WEST SUSSEX COUNTY COUNCIL CONSULTATION

TO:	Arun District Council FAO: Simon Davis
FROM:	Stephen Gee WSCC – Highways Authority
DATE:	20 May 2025
LOCATION:	Land to the West of New Courtwick Lane Wick BN17 7RZ
SUBJECT:	LU/72/25/OUT Hybrid Planning Application comprising of the following: 1)-Outline application with all matters reserved (except access) for Phase 2 (West of Site) comprising development of approximately 8,800sqm GIA Light Industrial/Storage and Distribution (Use Class E(g)(iii) / B8), and 2)-Full Application for Phase 1 (East of the Site) for a food store (Use Class E(a)), 2 No Drive-Thru food/beverage units (Sui Generis) with revised vehicular access, associated parking and landscaping. This application may affect the setting of a listed building and is in CIL Zone 2 and is CIL Liable.
DATE OF SITE VISIT:	Officer familiar with site.
RECOMMENDATION:	More Information

Figure 7 - Proposed Site Masterplan

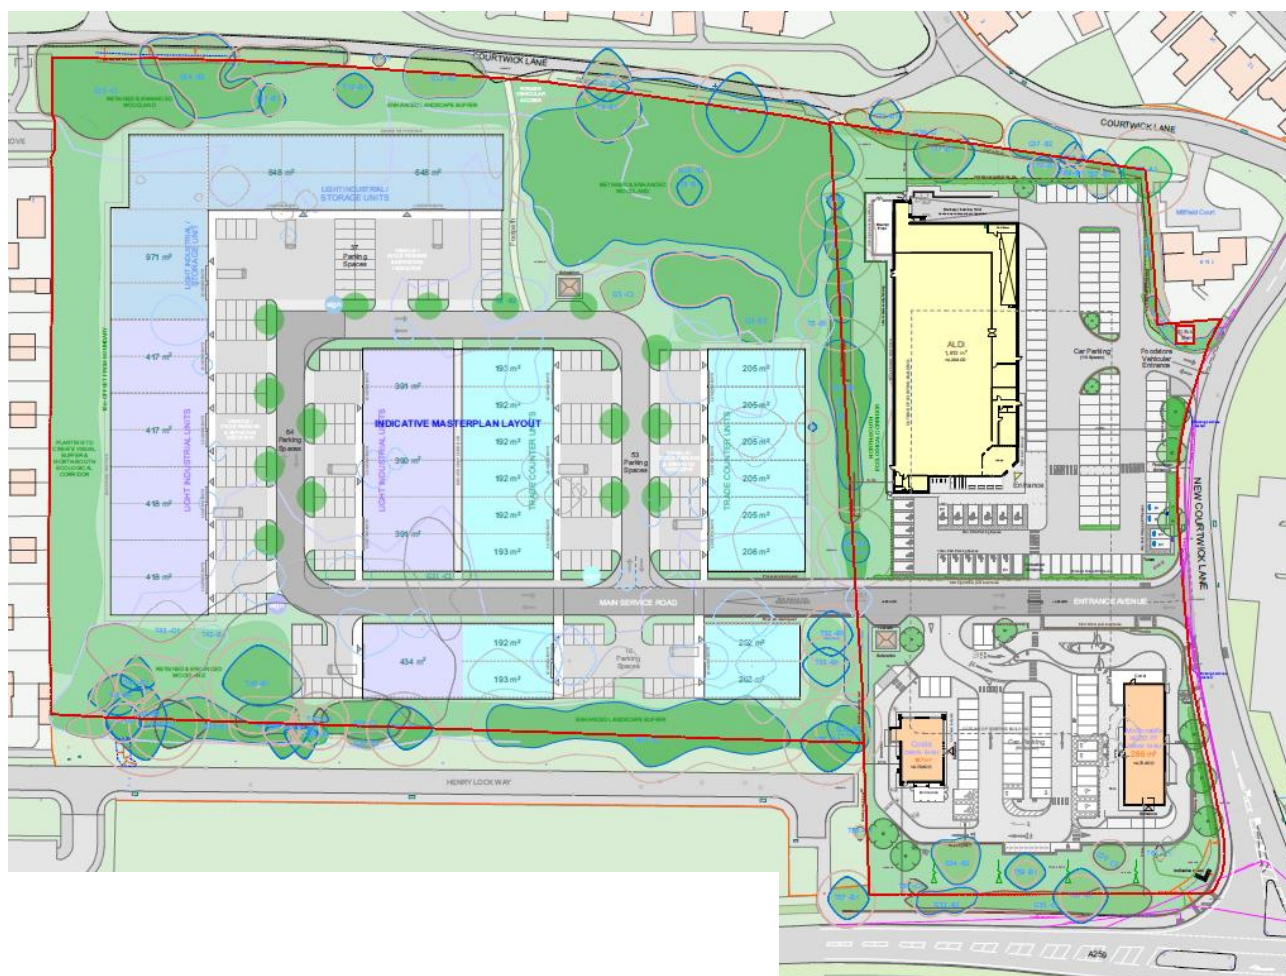
The phase 2 layout shows a footway being provided onto Courtwick Lane to the north at a former vehicular access (stated as existing pedestrian access within the planning statement). The footway would provide some permeability through the site. From the supporting plans provided works would be required outside the redline boundary to provide a connection to the carriageway and it does not appear on the WSCC Highway boundary mapping.

Through the pre application discussion the applicant has agreed to extend the shared footway/cycleway around the corner from the A259 and into the site/make appropriate connections from New Courtwick Lane. Including a right hand turn cycle lane in the existing hatched area. The shared use facility would terminate at the internal crossing between the drive thru restaurants and the food store.

The cycle proposals have not been included within the RSA process and should be done so.
